The Sizewell C Project

Notification of Proposed Project Changes

PINS Reference Number: EN010012

October 2020

SECTION B - B
SCALE 1:200

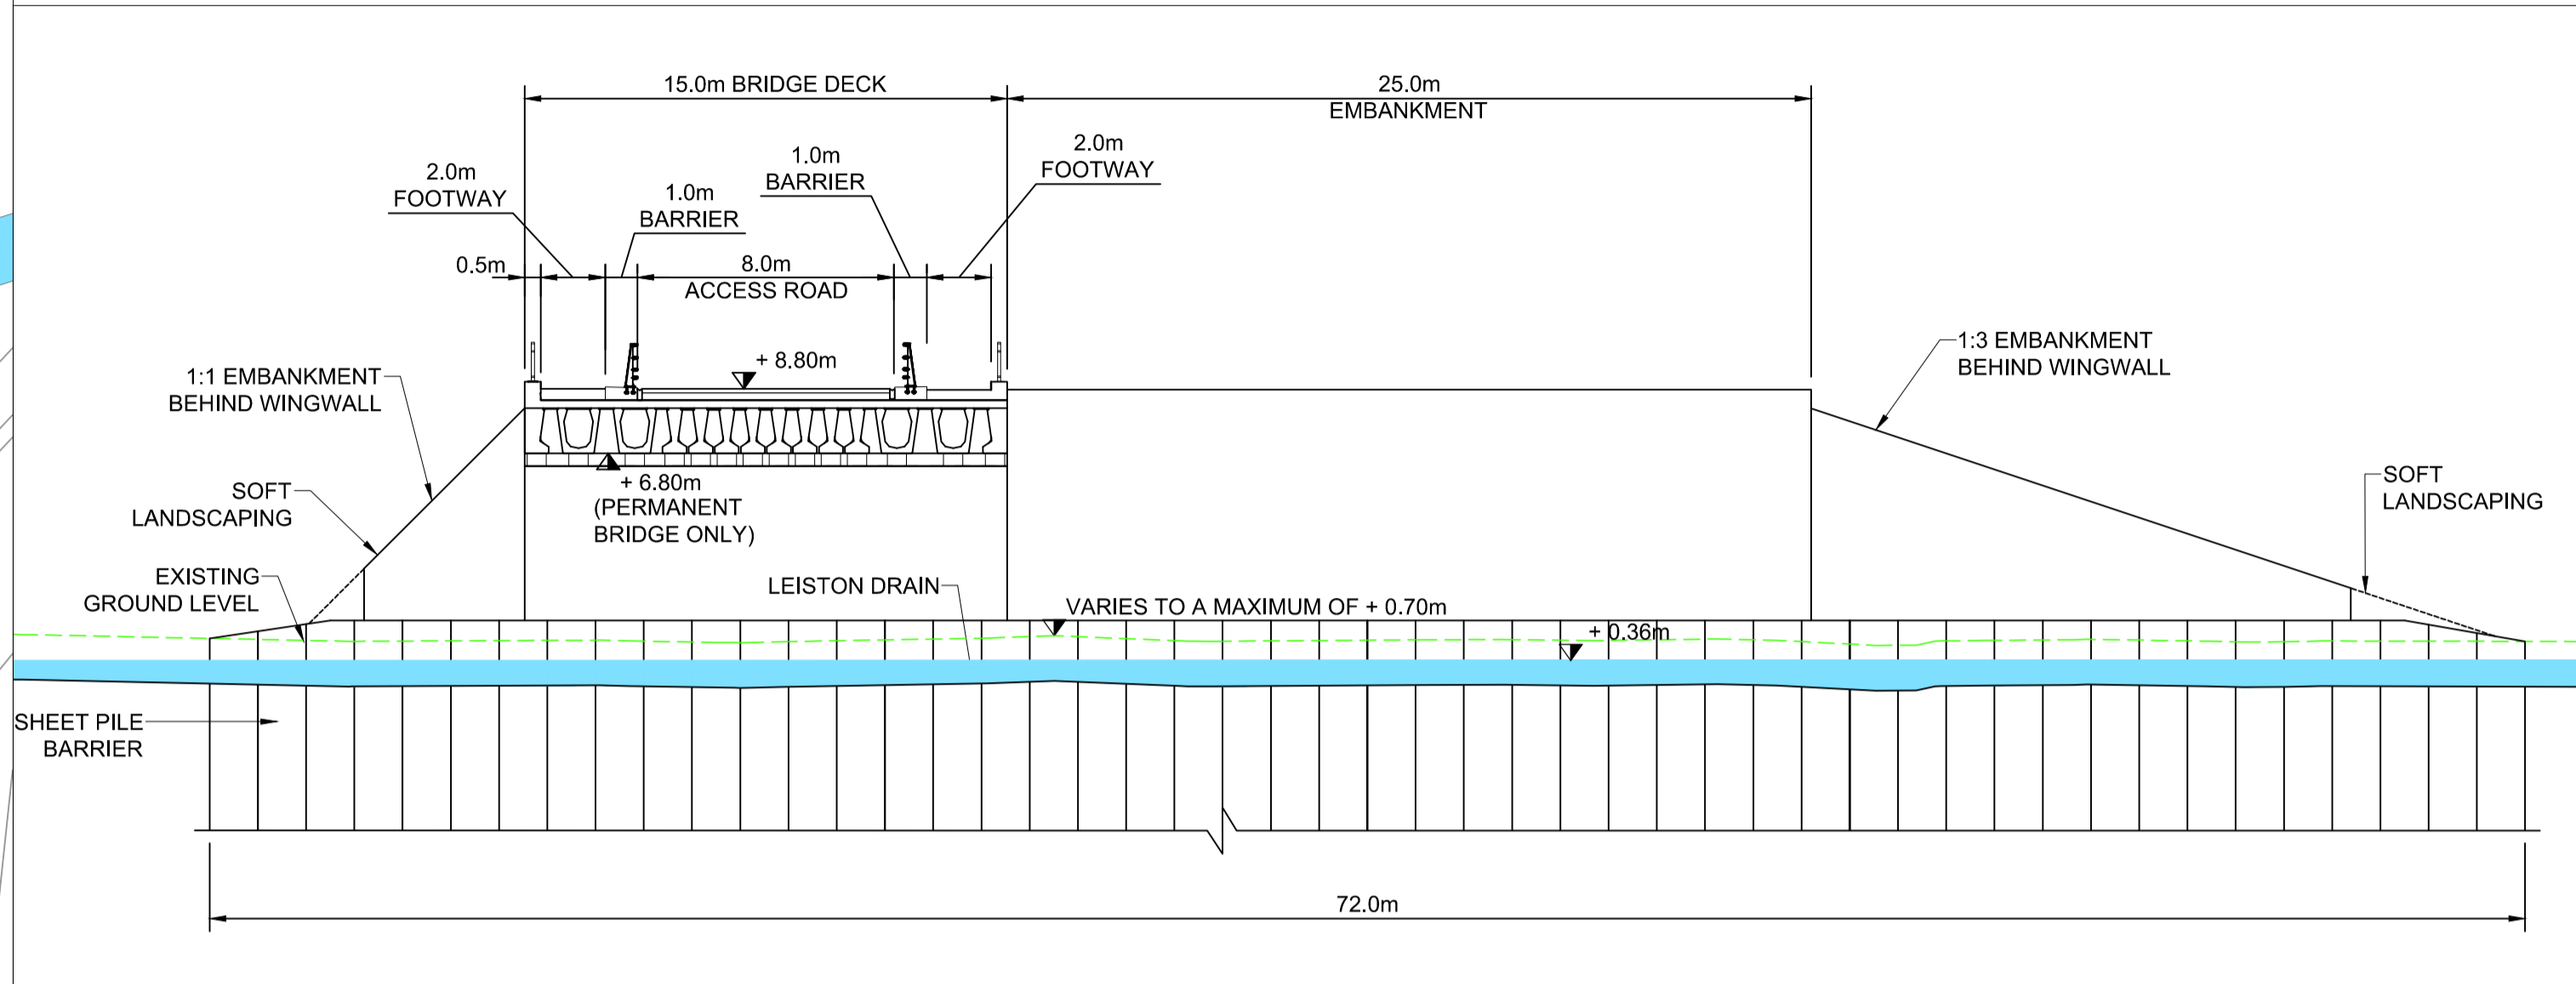
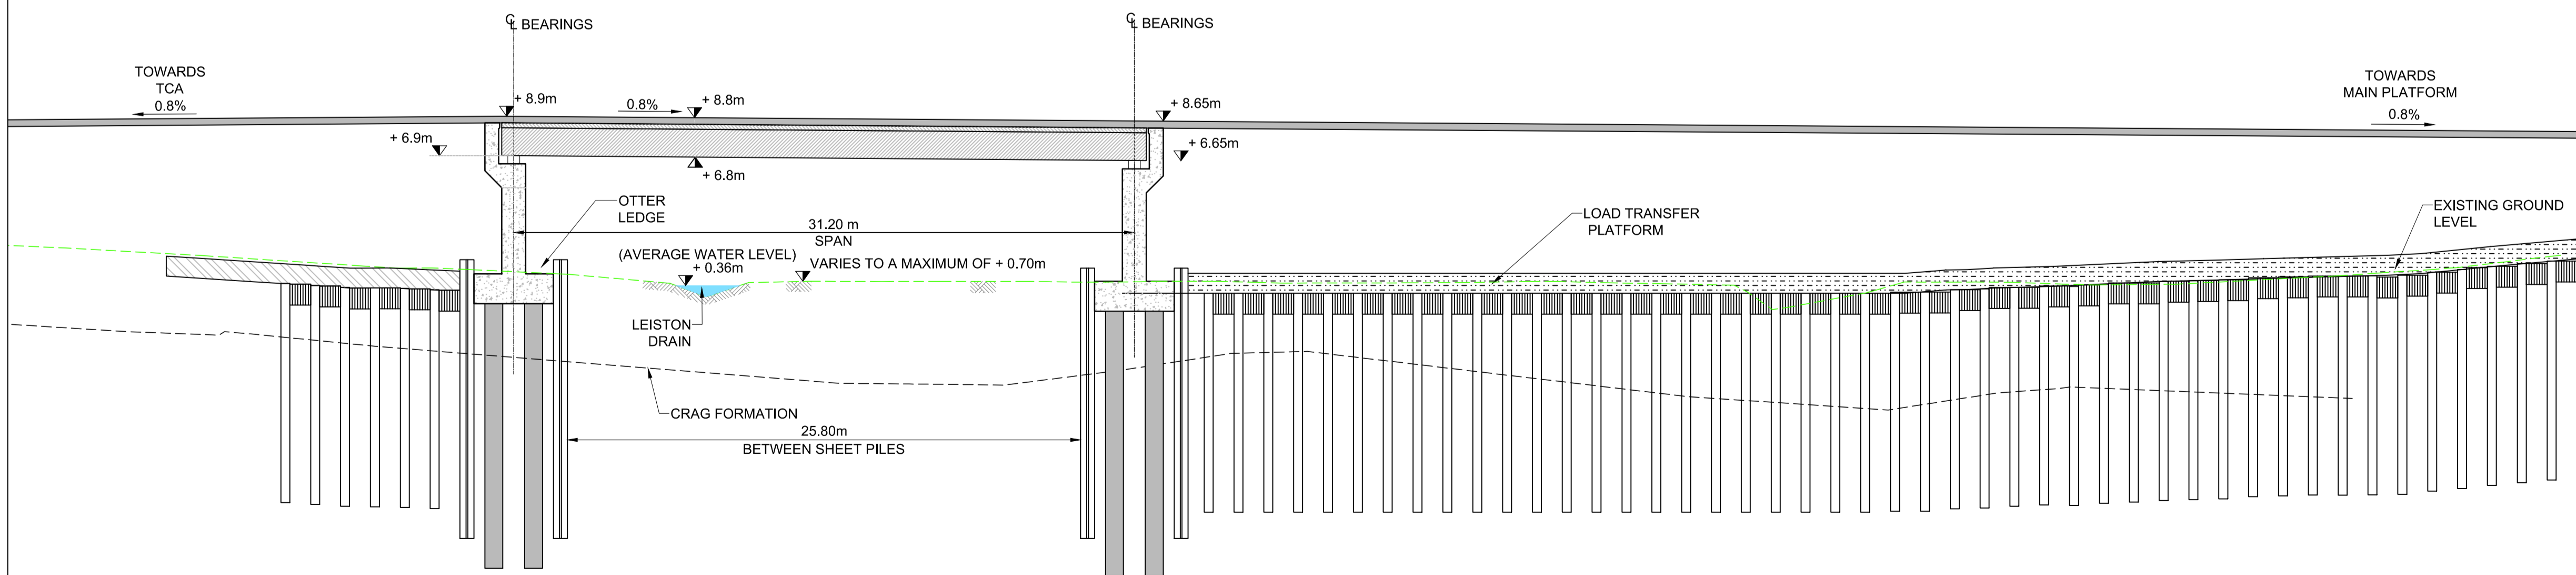
2.3.17 SZC Co. proposes to embed additional flood risk mitigation into the design of the SSSI Crossing by introducing additional flood relief culverts. This will enhance the mitigation already proposed at the crossing, namely the substantially oversized main culvert.
